M60/M62/M66 Simister Island Interchange

TR010064

7.19 APPLICANT'S RESPONSES TO DEADLINE 1 SUBMISSIONS

Version	Date	Status of Version
P01	15 October 2024	Deadline 2

Drawing number: HE548642 - JAC - LDC - SII_MLT
 Originator: JAC
 Volume: -DR- Z -1001

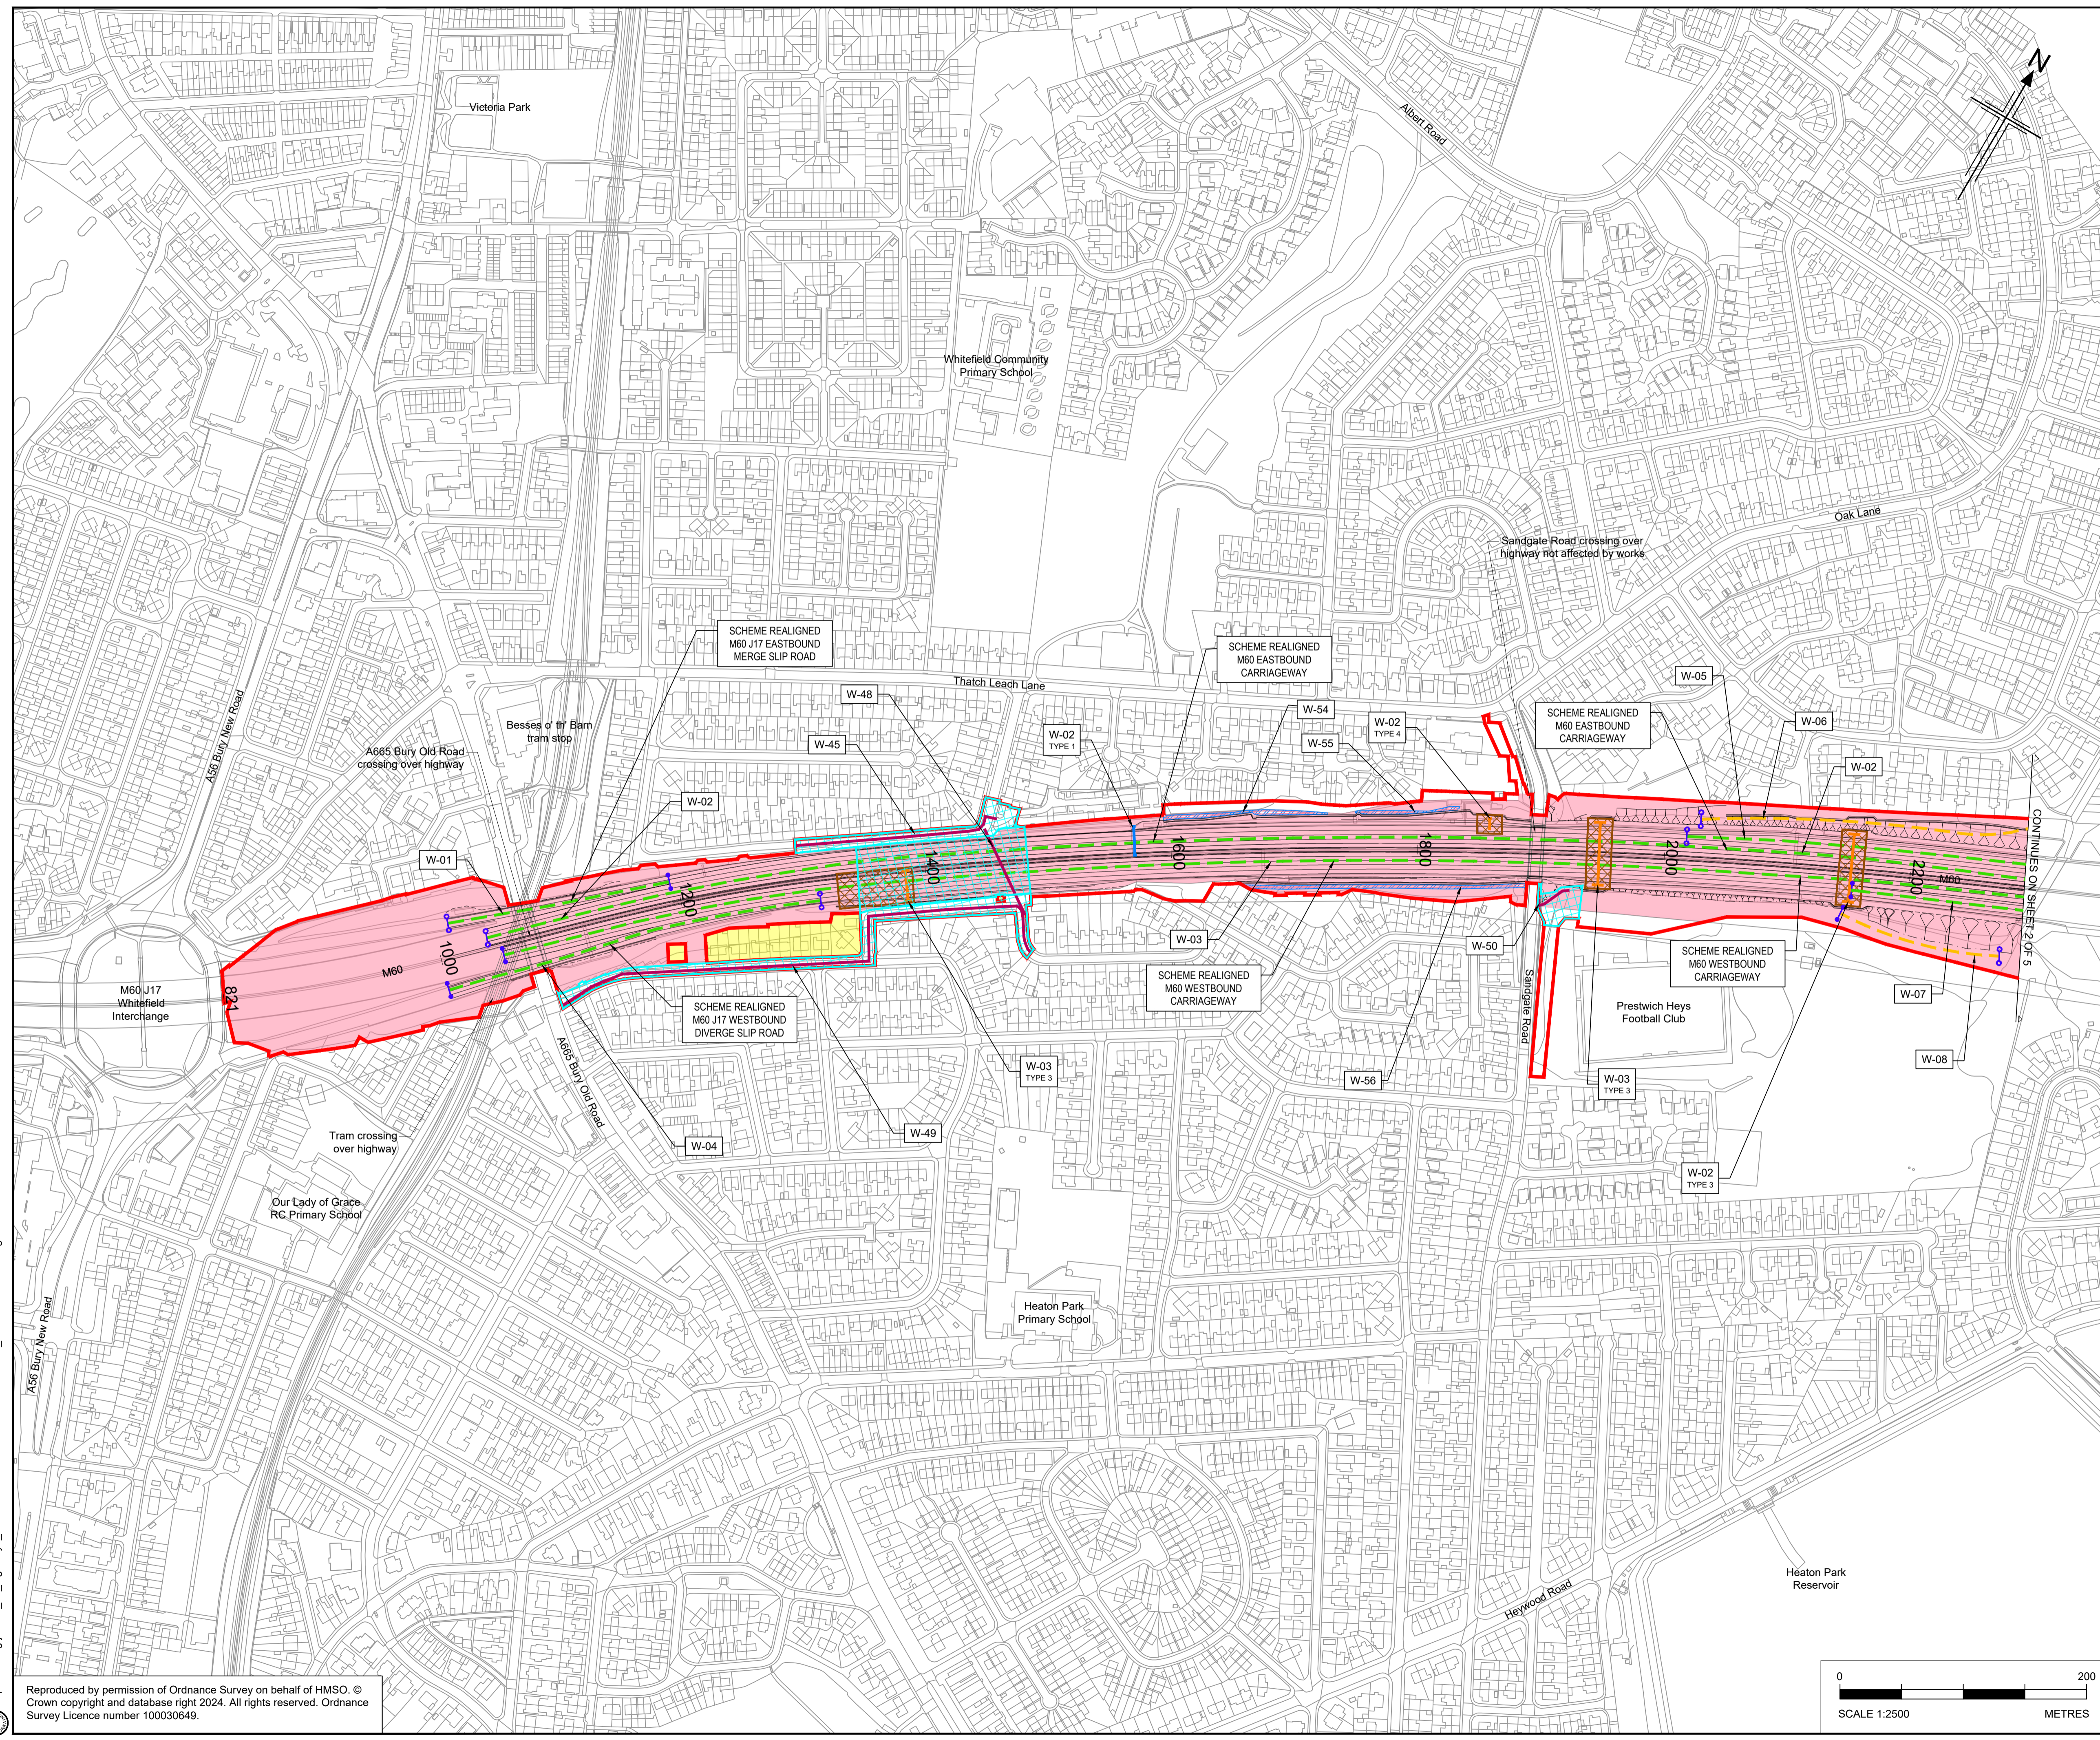
REP1-033b	<p>1. Purpose of the Acquisition</p> <p>In the Statement of Reasons, National Highways have failed to justify why the land falling within our client's ownership is required.</p> <p>There are two parcels of land within our client's interest to be acquired:</p> <ul style="list-style-type: none"> - Parcel 1/33a is to be acquired on a temporary basis - Parcel 1/33b is to be acquired on a temporary basis with a permanent acquisition of access rights. <p>Appendix A of the Statement of Reasons fails to detail the justification for the</p>	The Applicant confirms that, as set out in Annex A of the Statement of Reasons, plot 1/33a as shown on the Land Plans [AS-005] is required temporarily by the Applicant to facilitate Work No. 2 and associated ancillary works such as amendments to the motorway communications infrastructure associated with the new cantilever gantry that is to be provided south of plot 1/33a. Work No. 2 also includes the installation of a new retaining wall south of plot 1/33a to accommodate the new hard shoulder and regrading of the existing cut slope, installation of access steps for maintenance from the top of the embankment to the new motorway technology cabinets and new gantry. The existing technology and street lighting buried infrastructure and above ground assets are located very close to the existing boundary fencing and, as such, it is envisaged that plot 1/33a will be temporarily used in the event that any fence panels need to be temporarily removed to undertake works to the technology and street lighting infrastructure. Temporary inspections will also be required along the rear of the existing barrier in this area whilst construction works are undertaken, in addition to any works which may be required to vegetation encroaching into the highway
